**Housing Strategy and Development Team
Housing Services
Planning Application Comments**

Planning Application Number: 21/02083/REM

Site Name: Land At Tappers Farm, Oxford Road, Bodicote, Banbury, OX15 4BN

Date of Comments: 06/01/2022

Proposed planning layout 0737-102

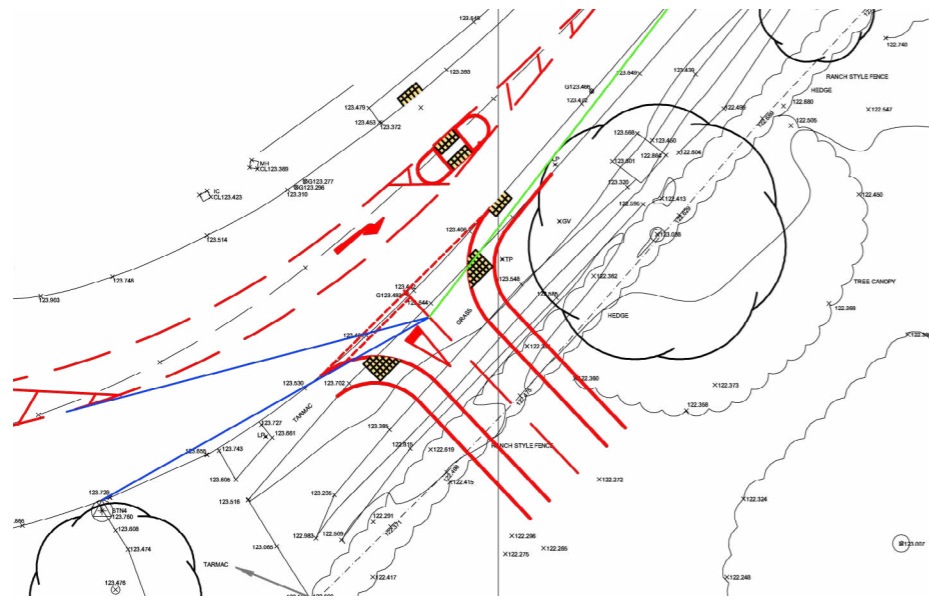
The only feature which may make the affordable dwellings stand out is the parking arrangement. The parking for plots 5 – 12 is in a continuous line of 12 bays, whereas for the rest of the site it is in smaller lines or located at the side of the dwellings. We would suggest that if it is not possible to change this, some soft landscaping would help to lessen the impact of the extended line of parking bays. It would also be helpful if they are allocated to the dwellings to

prevent the bays being viewed as a general purpose car park and ensuring that the residents' parking spaces are always available for their sole use.
